Our Case Number: ACP-324082-26

An
Coimisiún
Pleanála

Date: 21 September 2026

Re: The proposed development will consist of a 10-year planning permission for the construction of 1 Battery Energy Storage System, 1 110kV AIS electrical substation building and 1 single-storey customer substation building and all associated infrastructure located at Ballynanelagh, Kockraha, Co. Cork. (www.drumkeelcis.com)

Originator:	Version	Change Description	Author	Approver	Date
Noriker Power Ltd.	3.50	Finalised for planning	AP	JW	15/01/2026
<b>Project Title:</b>					
KNOCKRAHA BESS, CO. CORK					
<b>Drawing Title:</b>					
Site Layout - MAP "A"

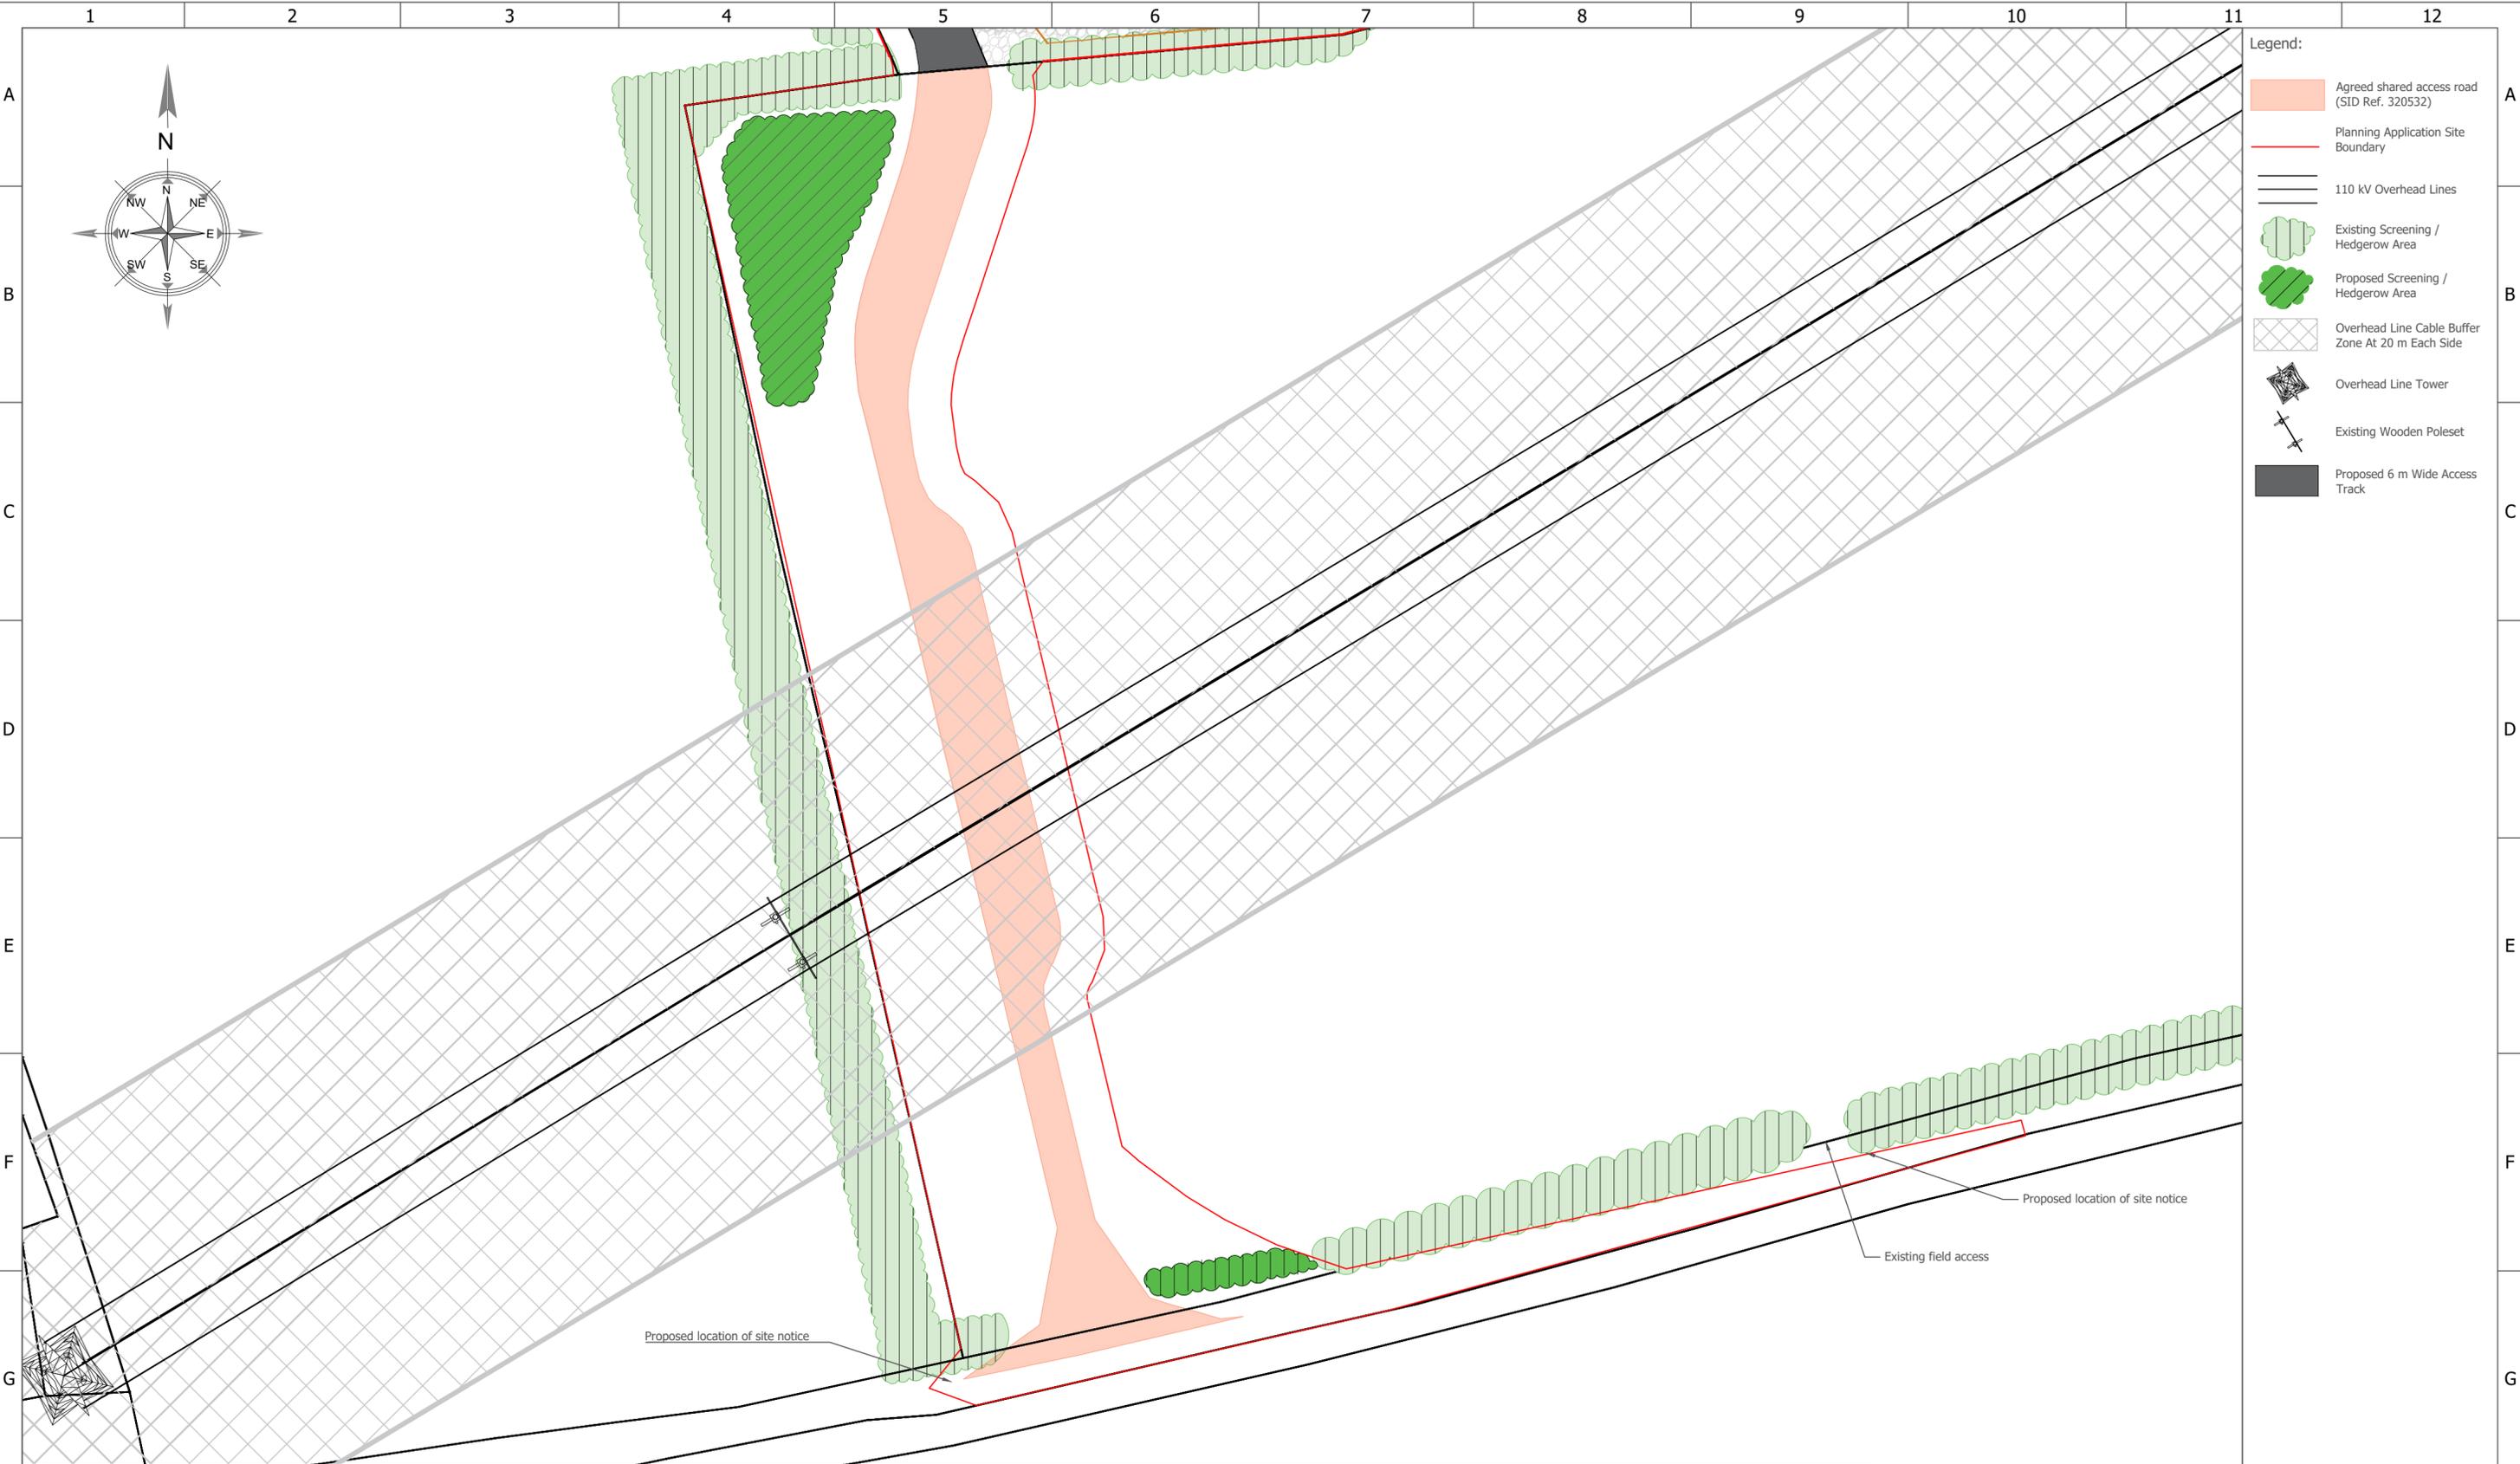
(i) Notwithstanding the applicant's proposal for a firewater reservoir to retain 500,000 litres of water for use in a fire event. The applicant is required to provide confirmation of how firefighting water will be sourced and/or retained within the proposed development site particularly during the summer months and periods of drought conditions. The quantity of firewater storage should be in line with the UK National Fire Chief's Council (NFCC) Grid Scale Battery Energy Storage System Planning – Guidance for the FRS (Fire & Rescue Services), which states that provision should be made for BESS units to provide 1,500 litres of water per minute for 2 hours, as a minimum unless it can be demonstrated that another amount is appropriate. Revised drawings and necessary agreements be provided to demonstrate feasibility of same.

Originator:	Version	Change Description	Author	Approver	Date	Transmission Type:
Noriker Power Ltd.	0.0	Finalised for planning	OP	JW	27/01/2026	External
Project Title:						Intended Paper Size: A2
KNOCKRAHA BESS, CO CORK						Scale: As Above
Drawing Title:						Sheet: 1 of 1
Typical Drainage Details

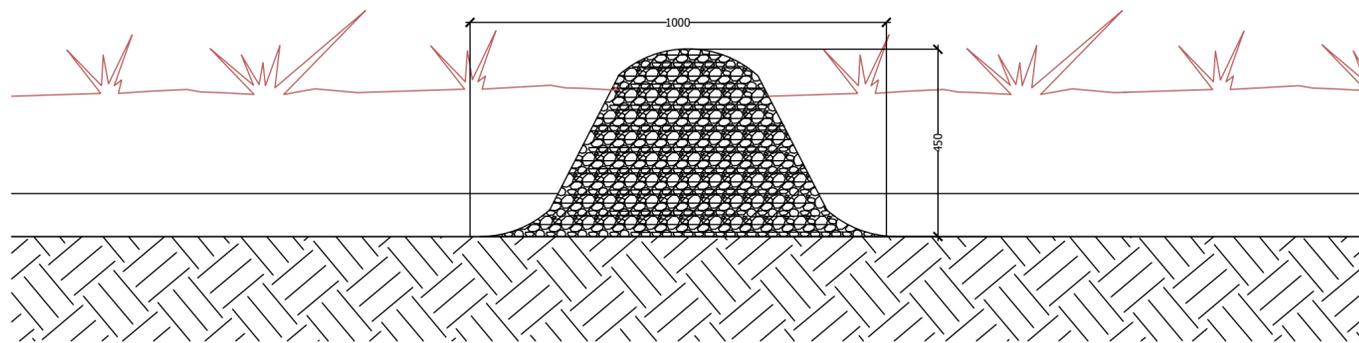
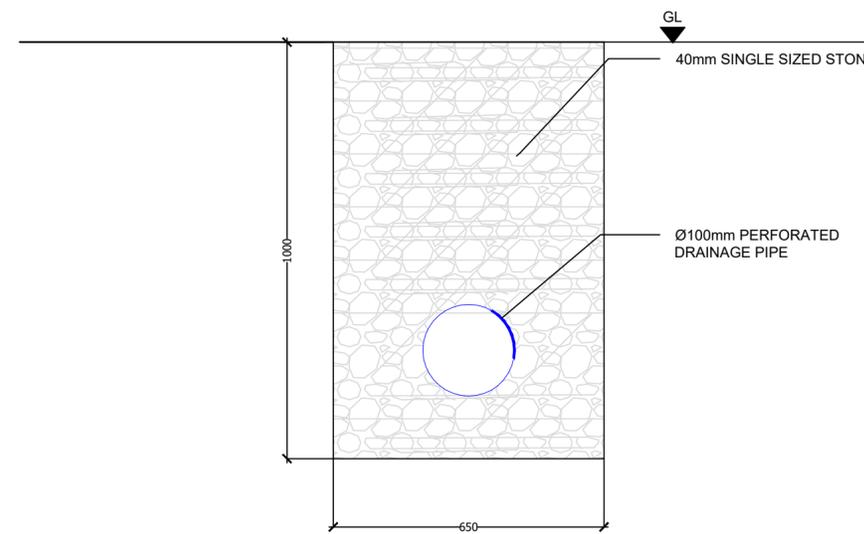
a) The plan shall include drainage proposals designed to manage rainfall runoff and fire water runoff, with associated calculations to be informed by the anticipated fire water requirements from the proposed development.

b) Drainage proposals shall include details to demonstrate that suitable catchment, containment, monitoring and on-site treatment measures would be in place for firewater runoff and other potential firefighting substances (such as foam) and details of any mitigation necessary to ensure that there will be no contamination or impacts on surface or groundwater from firewater and that consideration has been given to any potential downstream and/or drinking water abstraction impacts.
